Subject: RE: Rustington Convalescent Home - R/93/25/DOC

Flood Risk and Drainage Engineer, Coastal Engineers and Flood Prevention

Subject: RE: Rustington Convalescent Home

Job Title		SEA ROAD RUSTINGTON, WEST SUSSEX	
Drawing Title		DRAINAGE LAYOUT SHEET 1 OF 3	
Client		MACAR HOMES (RUSTINGTON) LTD	
Scale	Date	Designed	AK
1:200 @A1	MAY 25		
Drawn	Checked	Approved	BAC
AK	BAC		
Job No	Drawing No	Rev	
25-043	25-043-105	B

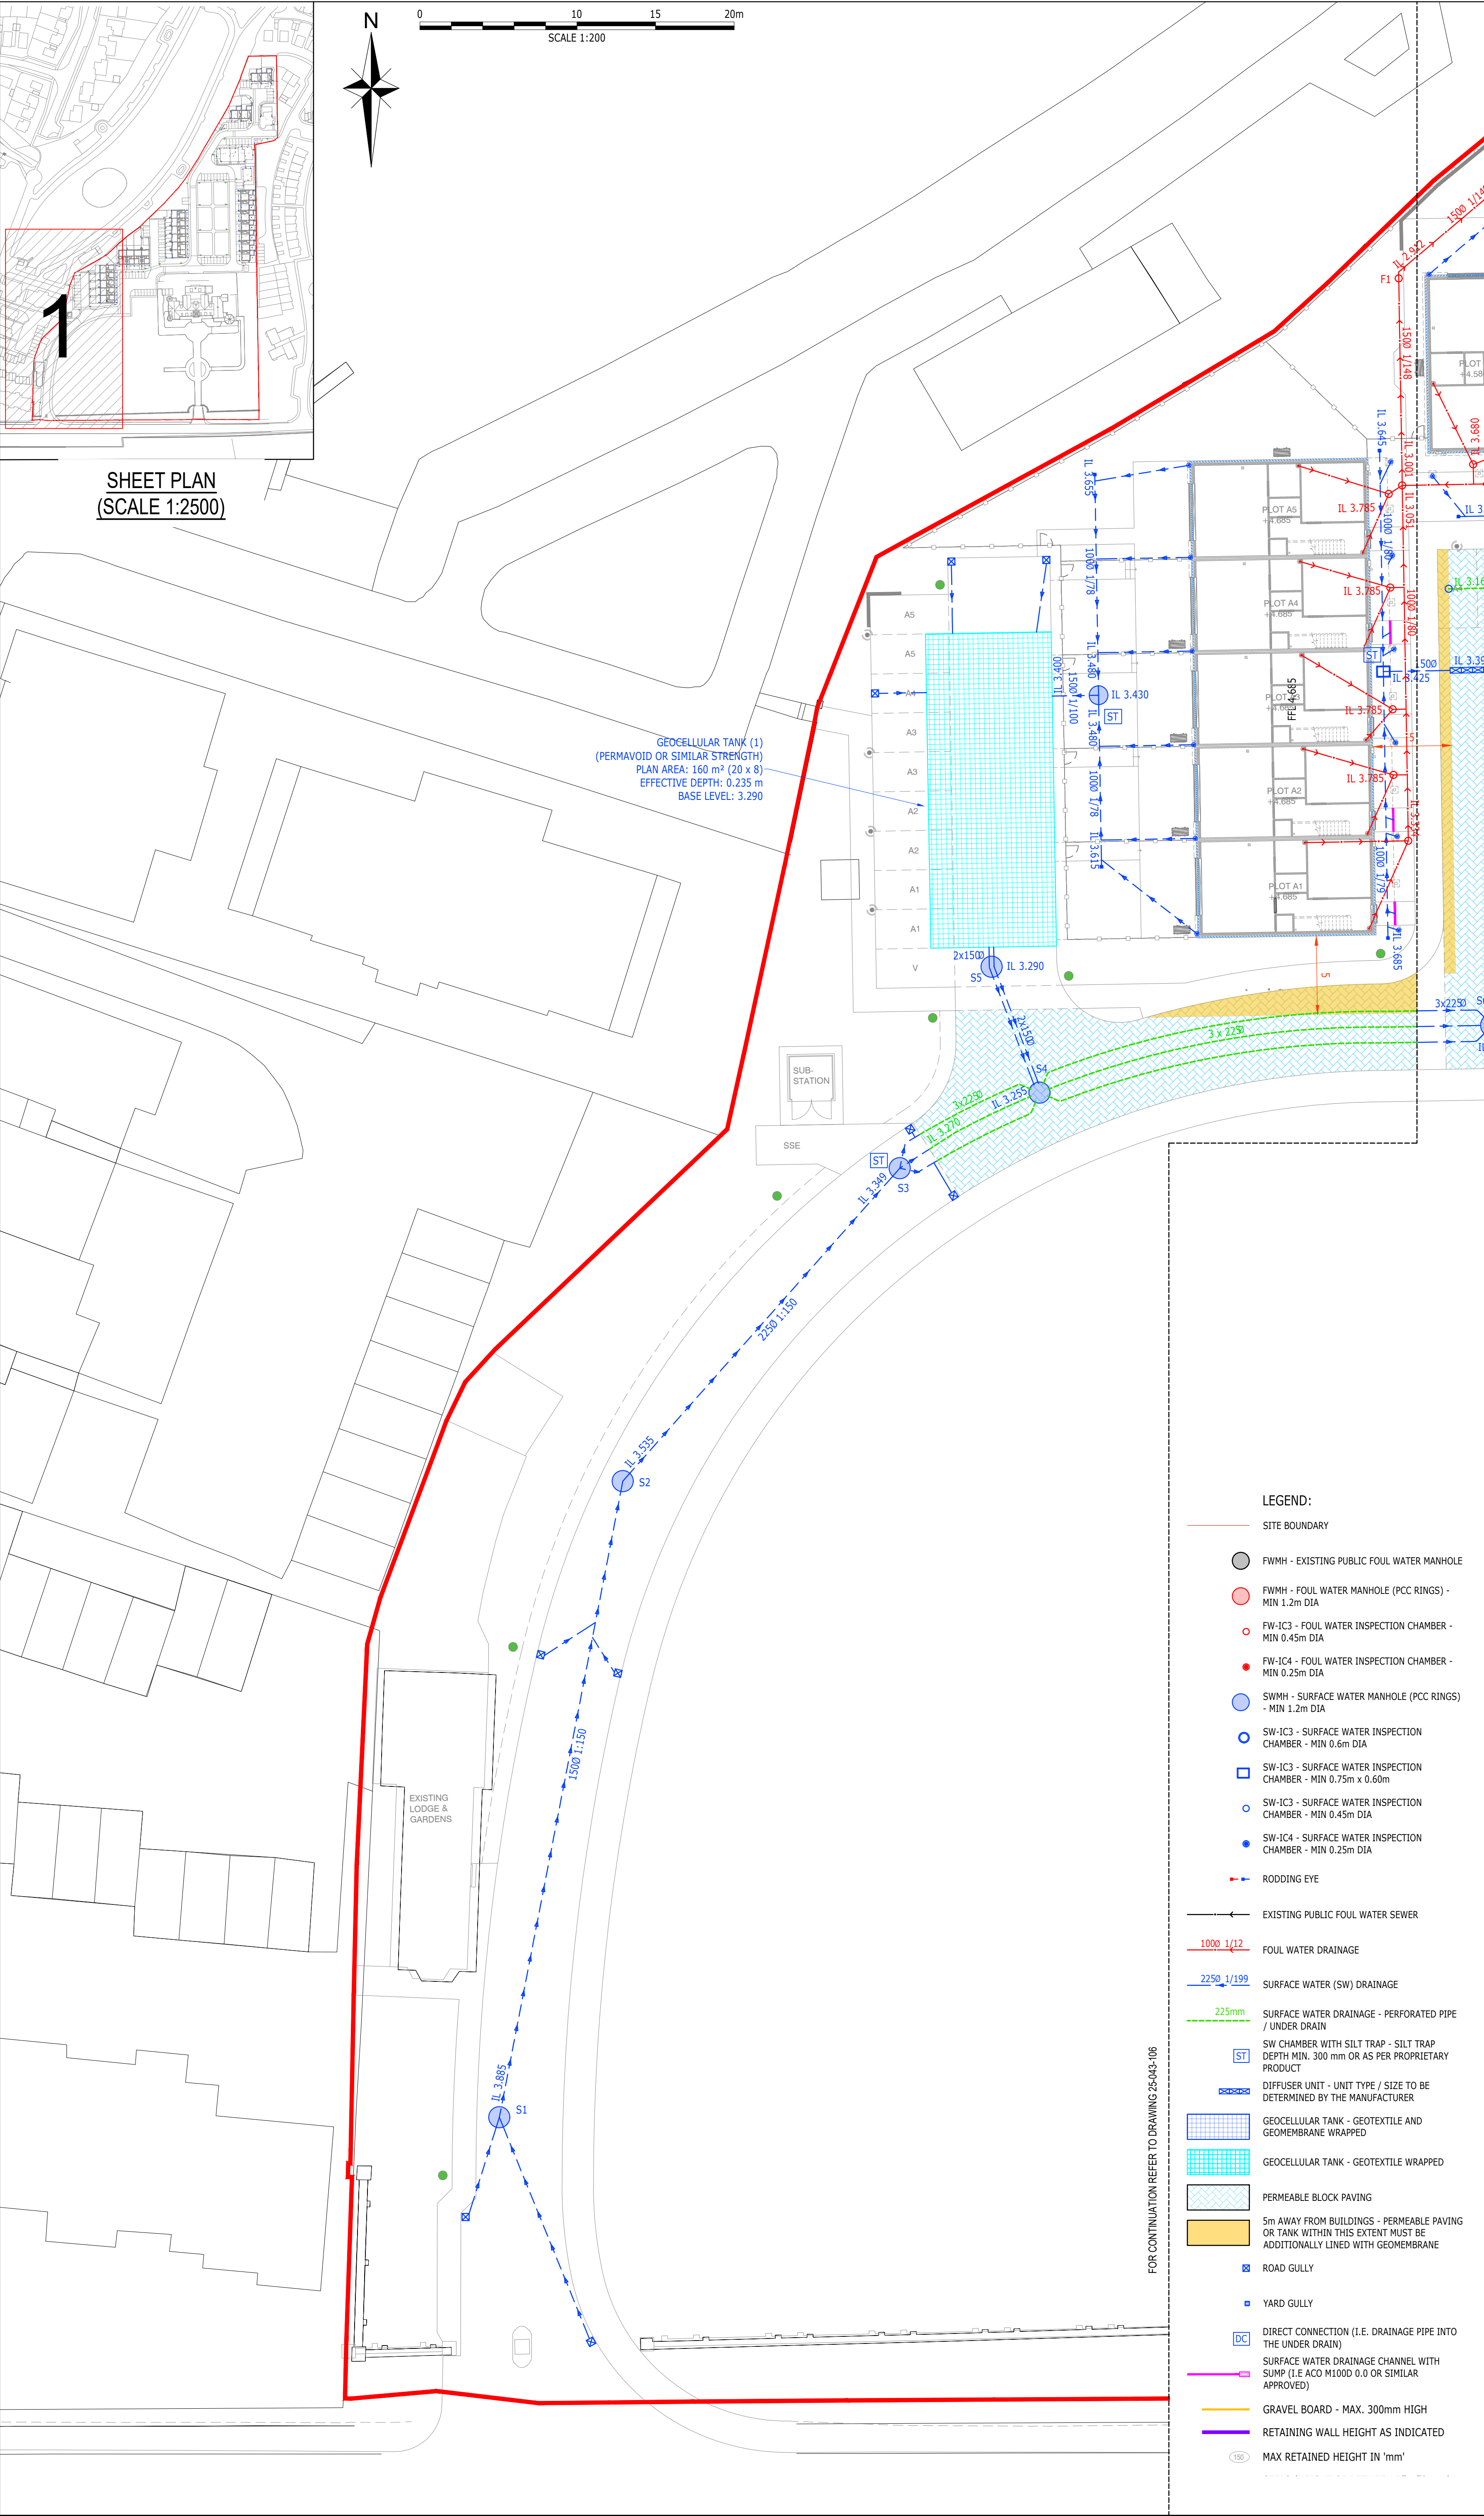
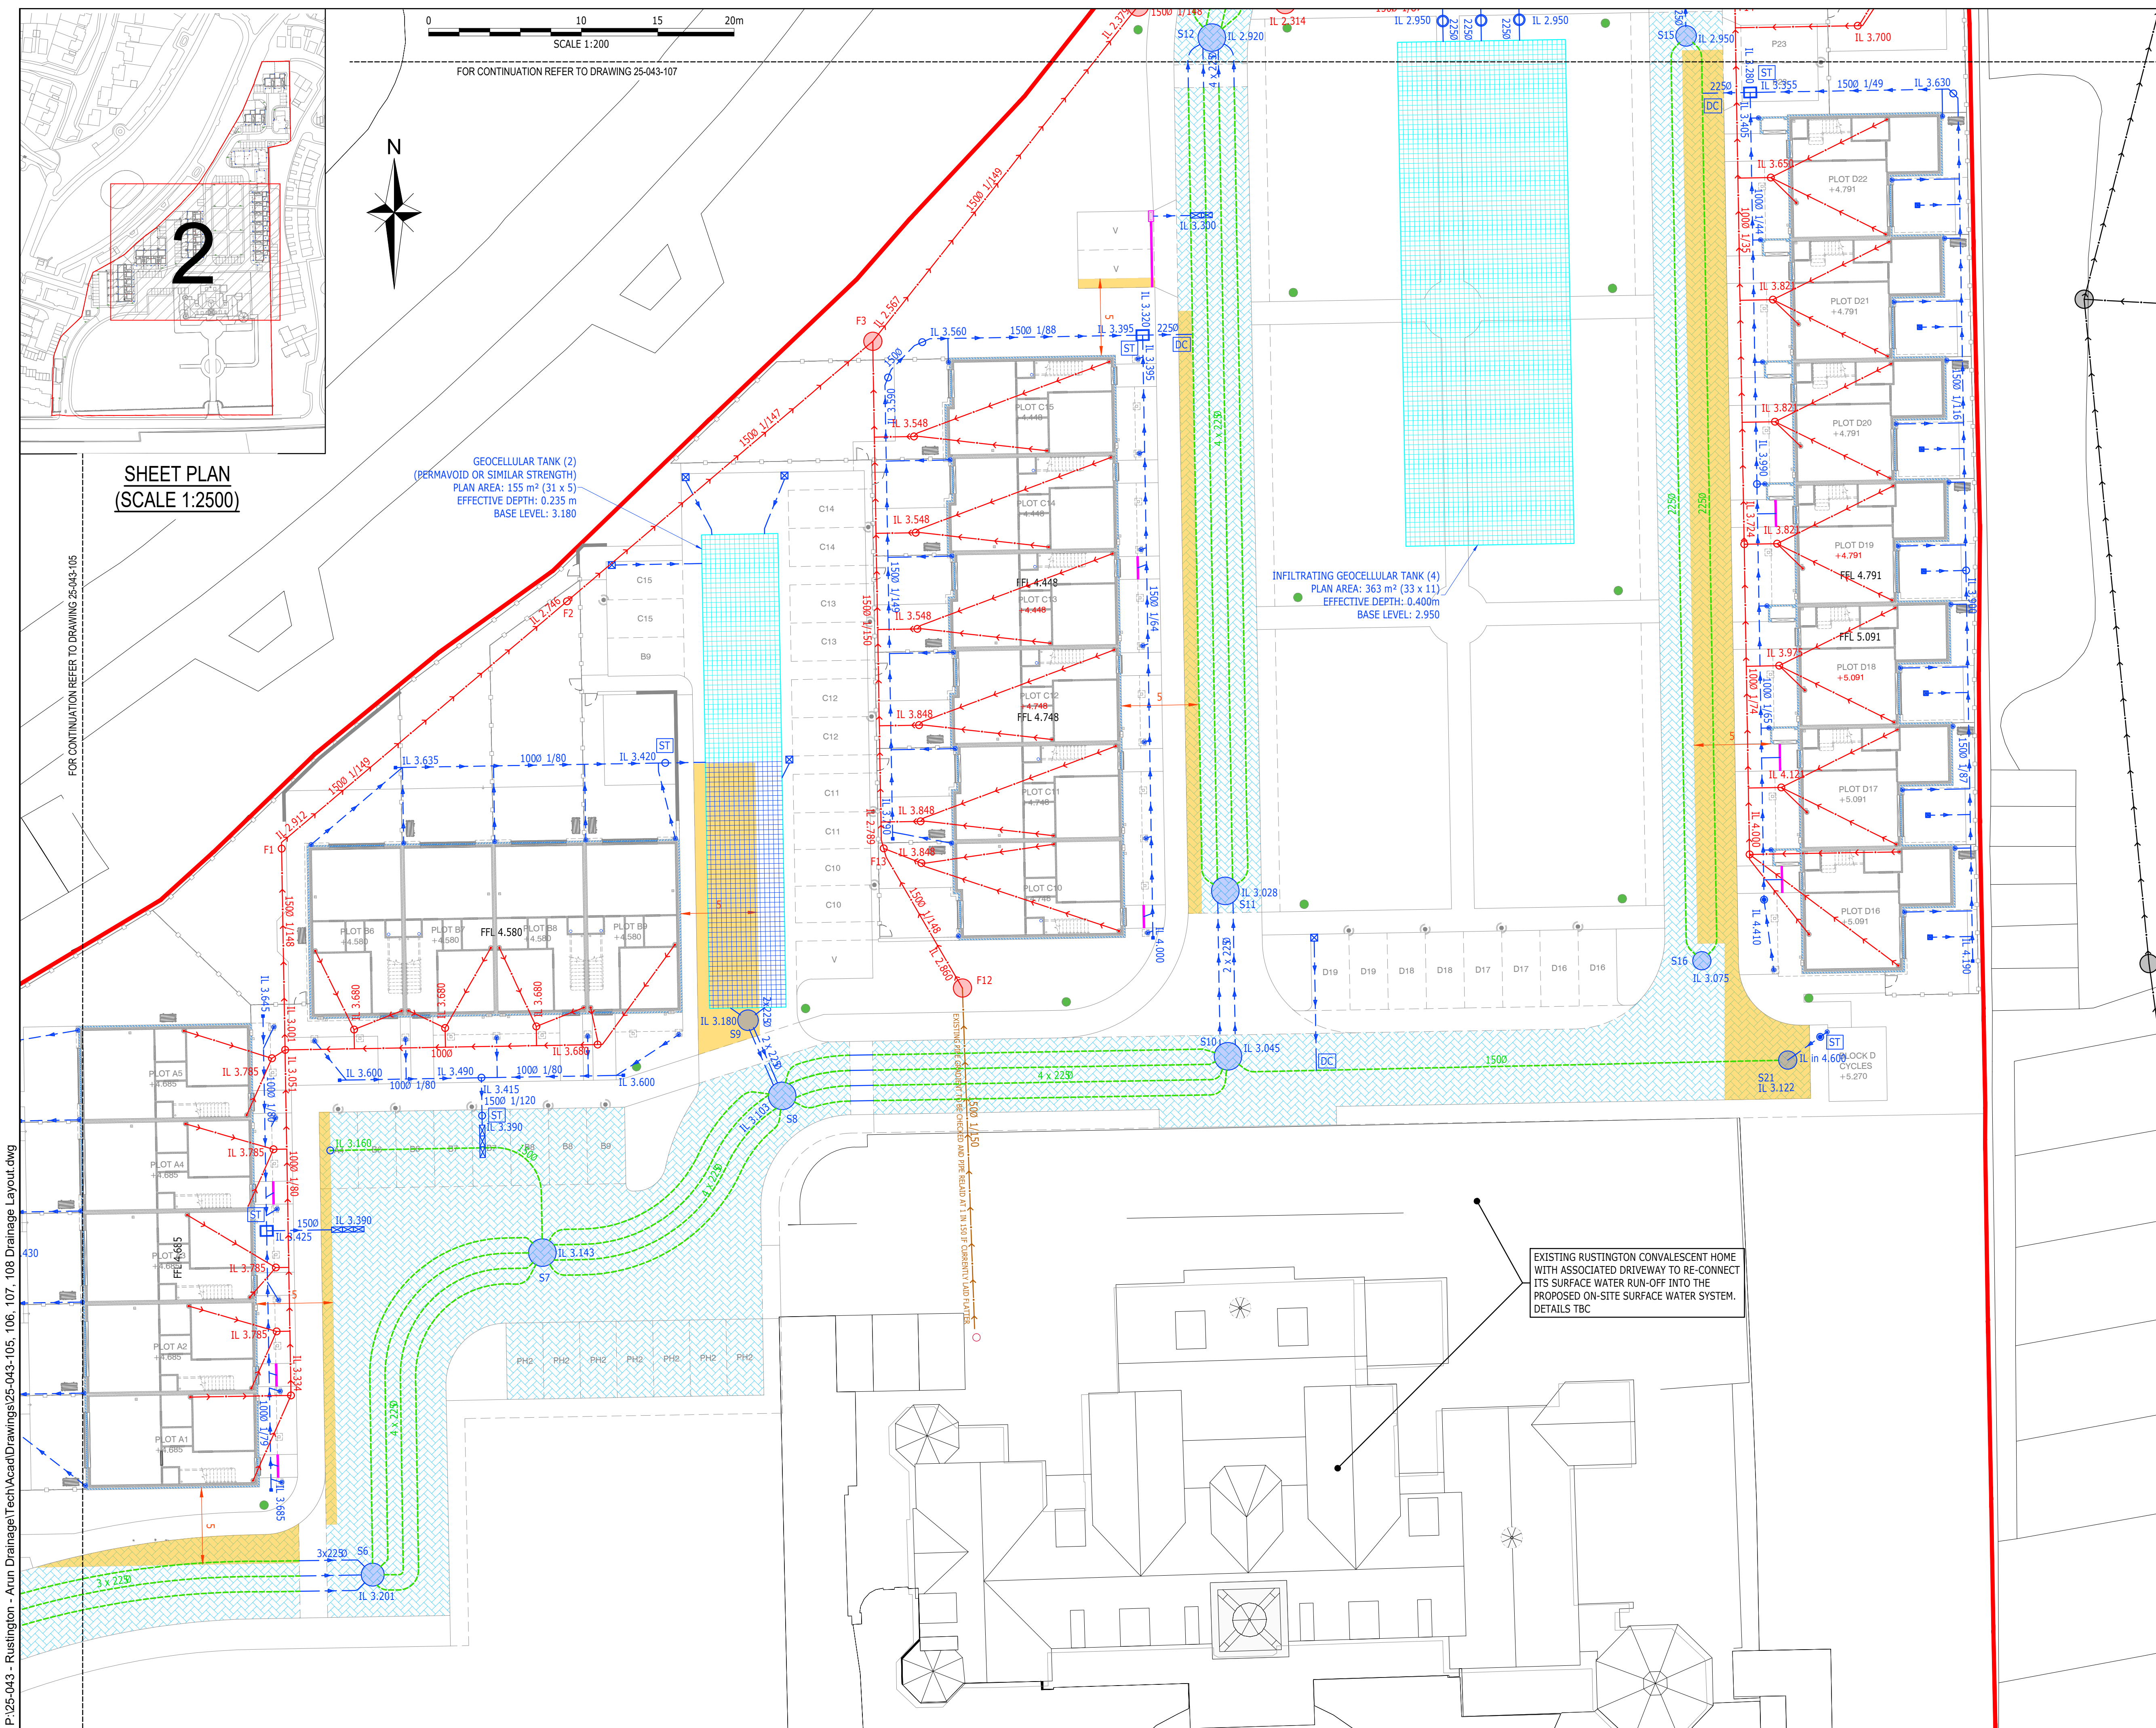
7. We have discussed this with the developer and their site experience suggests that impermeable liner can be cut on site to accurately accommodate the 5m distance away from the buildings. However, to comply with the comment we will 'straighten-up' the extent of the liner on plan where feasible and where it would not impact the infiltration potential of the permeable paving (PP) (namely liner layout at interface of PP21 and PP20 would remain as currently shown). In relation to underdrain comment - we need underdrains to assist the flow through the permeable paving. We have implemented either long and shallow bends and sharper bends are located close to the maintenance manhole and so CCTV/jetting equipment could be used and implemented from the nearby maintenance manholes. **Noted. Please provide your updated plans showing the generalised of this liner as we requested. Why are underdrain required if infiltration is viable at the source?**

7. We have discussed this with the developer and their site experience suggests that impermeable liner can be cut on site to accurately accommodate the 5m distance away from the buildings. However, to comply with the comment we will 'straighten-up' the extent of the liner on plan where feasible and where it would not impact the infiltration potential of the permeable paving (PP) (namely liner layout at interface of PP21 and PP20 would remain as currently shown). In relation to underdrain comment - we need underdrains to assist the flow through the permeable paving. We have implemented either long and shallow bends and sharper bends are located close to the maintenance manhole and so CCTV/jetting equipment could be used and implemented from the nearby maintenance manholes.
